The Bramley Line Heritage Railway

Application by Medworth CHP Limited for an Order Granting Development Consent for the Medworth Energy from Waste Combined Heat and Power Facility Project (EfW CHP) (EN010110)

Secretary of State Consultation

02/02/2024

Figure 3.19i
New Bridge Lane access proposal

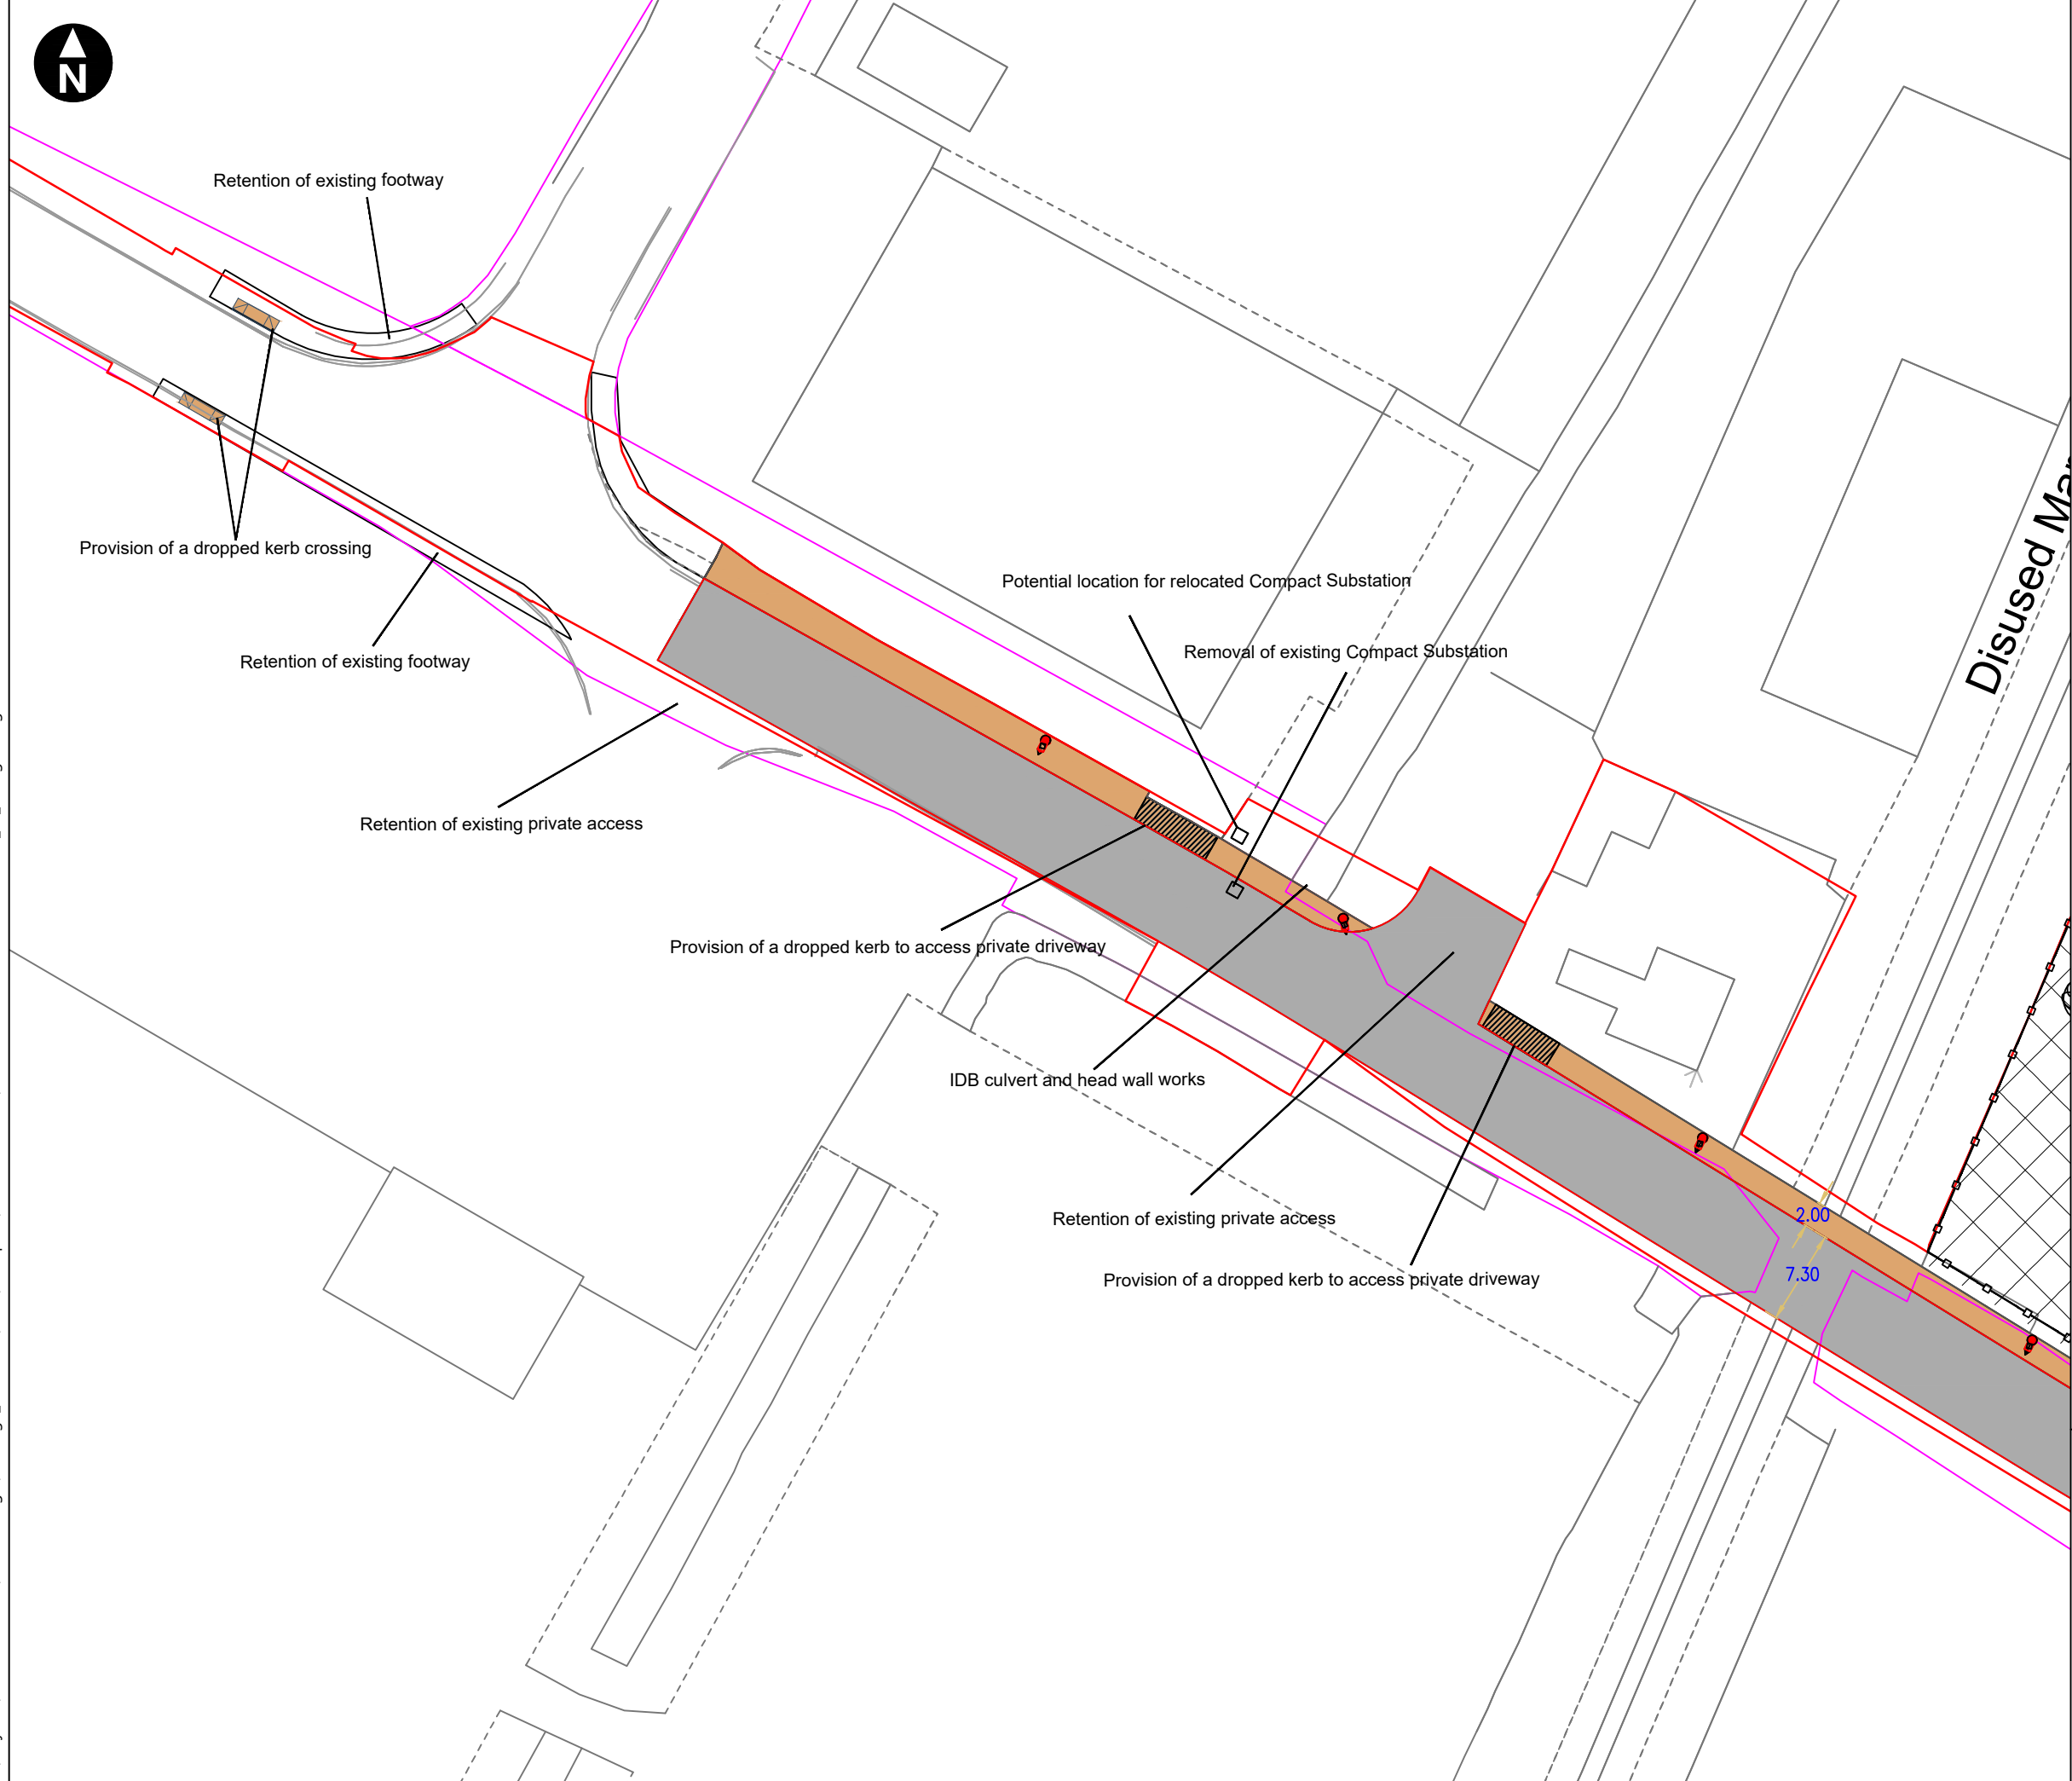
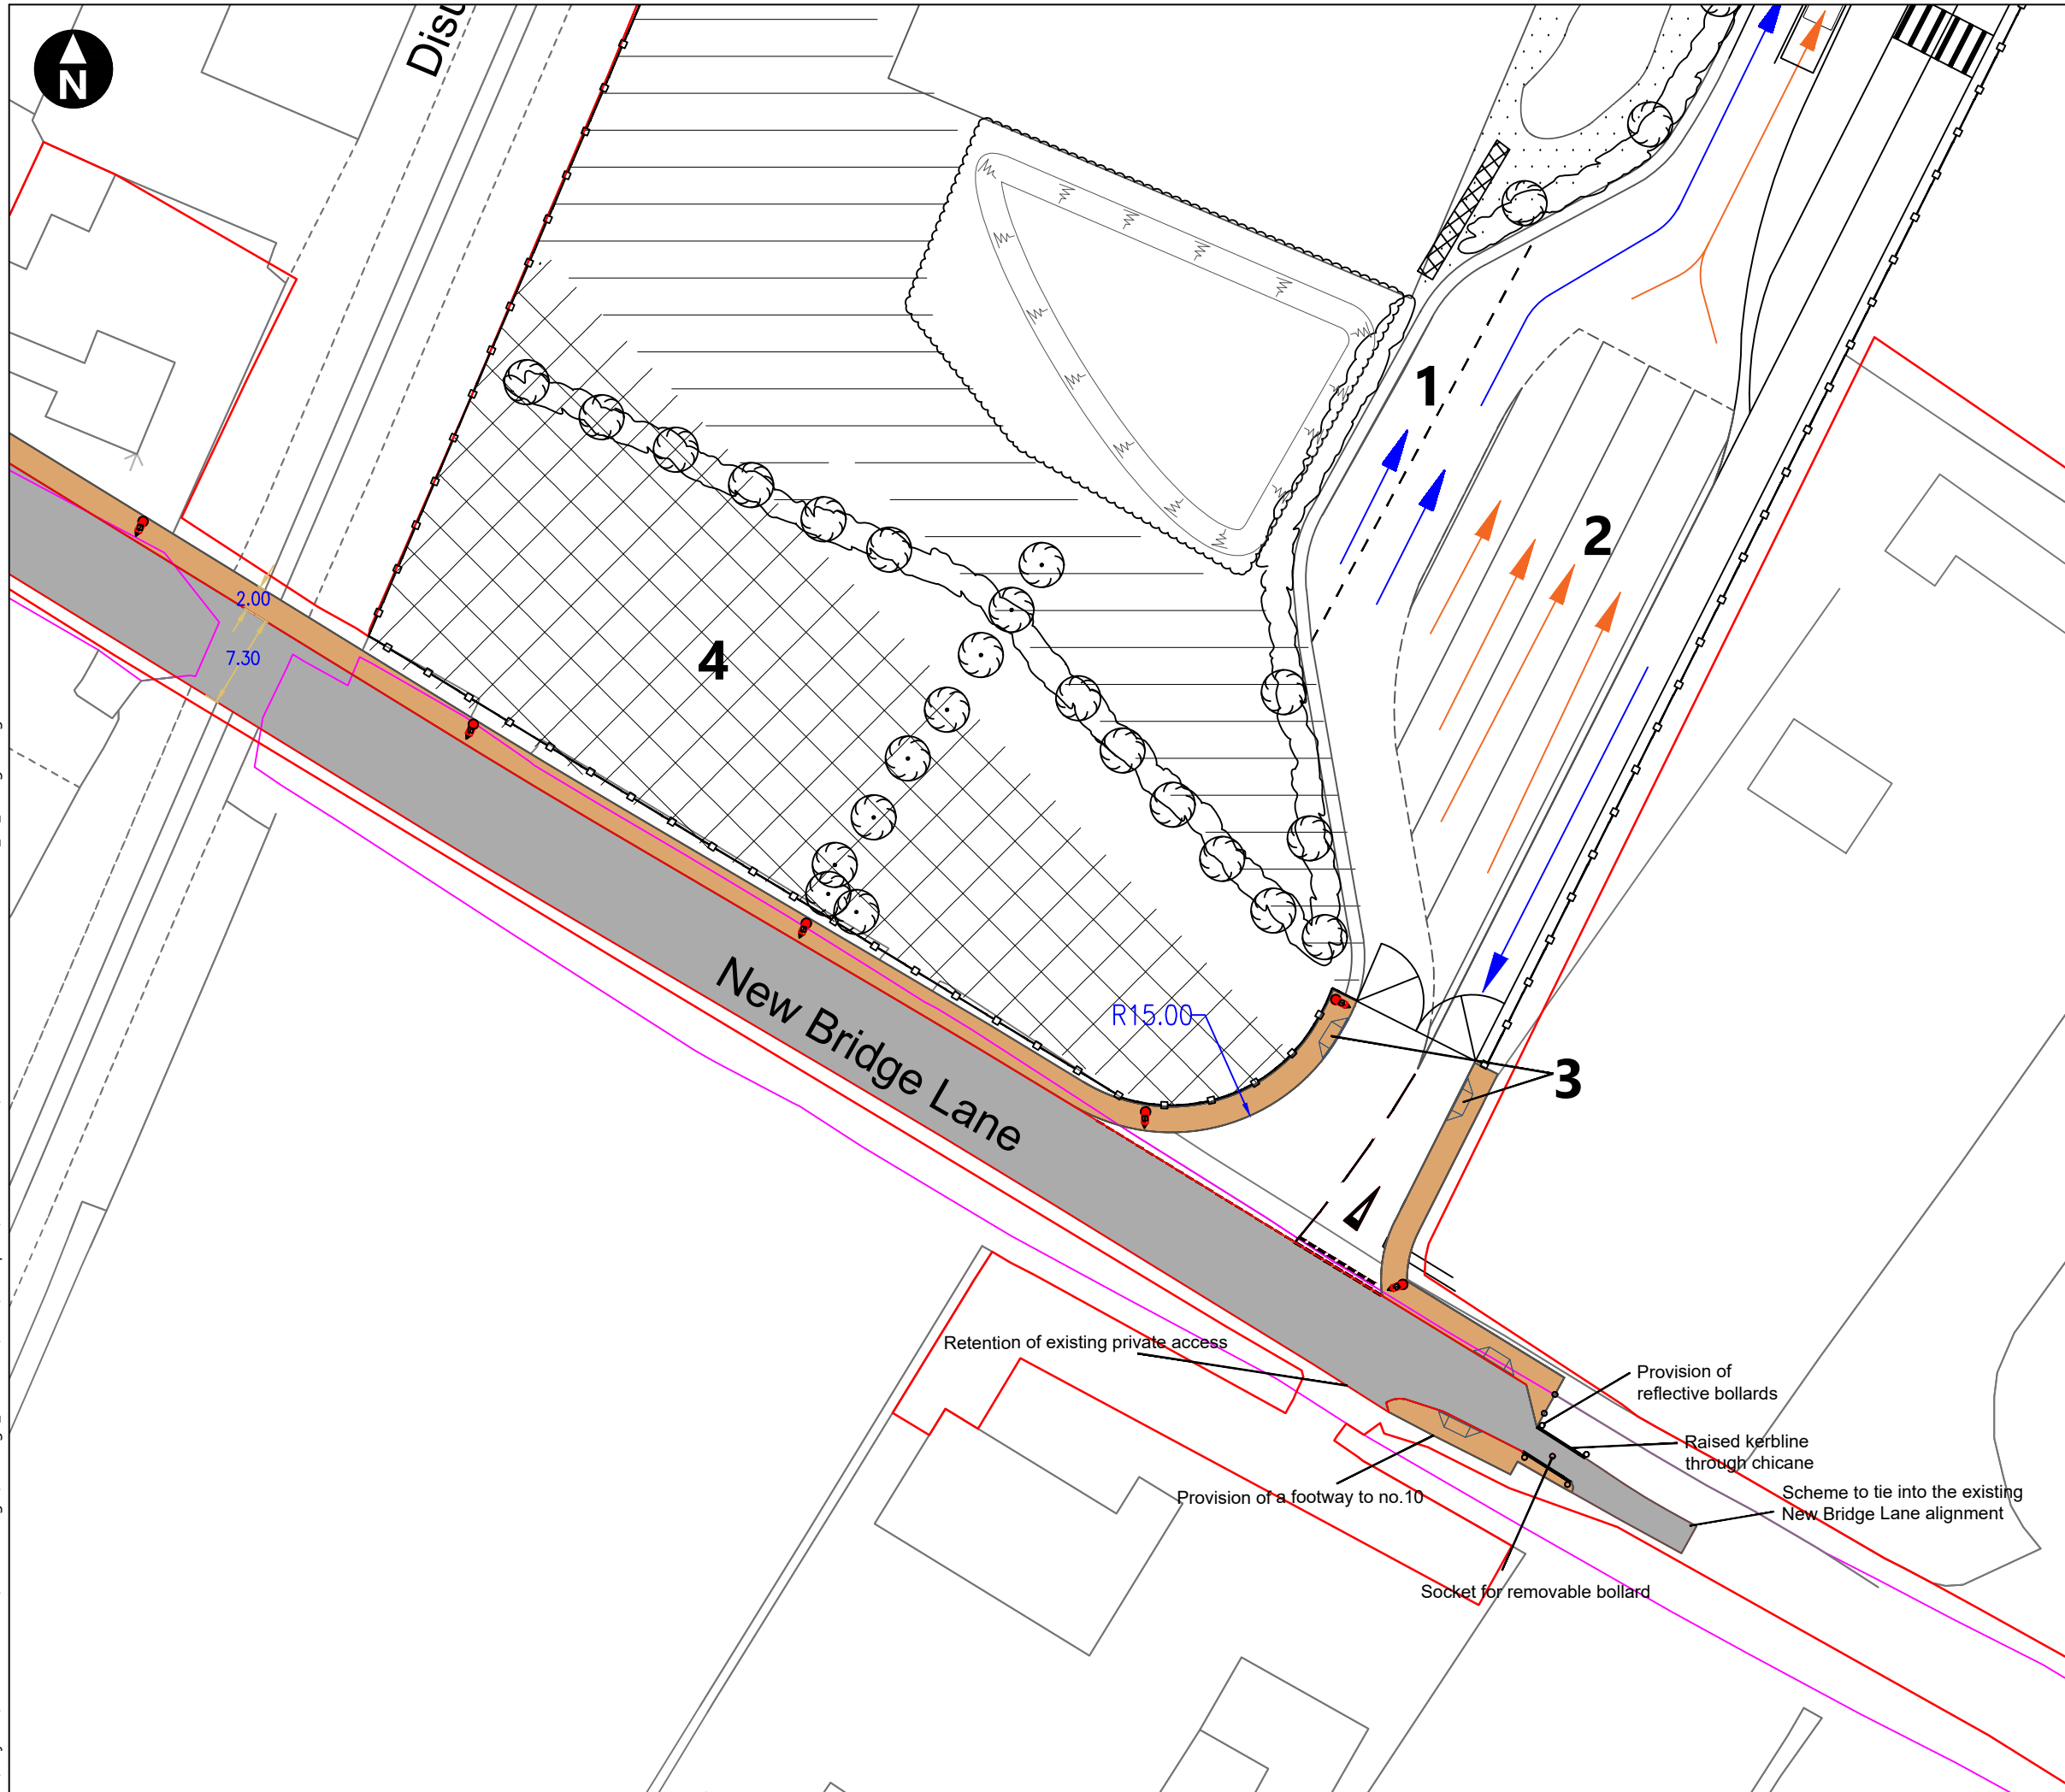
The siting of the access road to the EfW CHP Facility Site from New Bridge Lane and adjacent landscaping area has said to have been apparently designed to accommodate a future railway siding should delivery of waste by railway freight be feasible. If this is the case, and freight traffic is to use the line, heavy rail would have to be relaid and lineside obstructions adjacent to these sidings will have to be kept well outside the required loading gauge of rail vehicles.
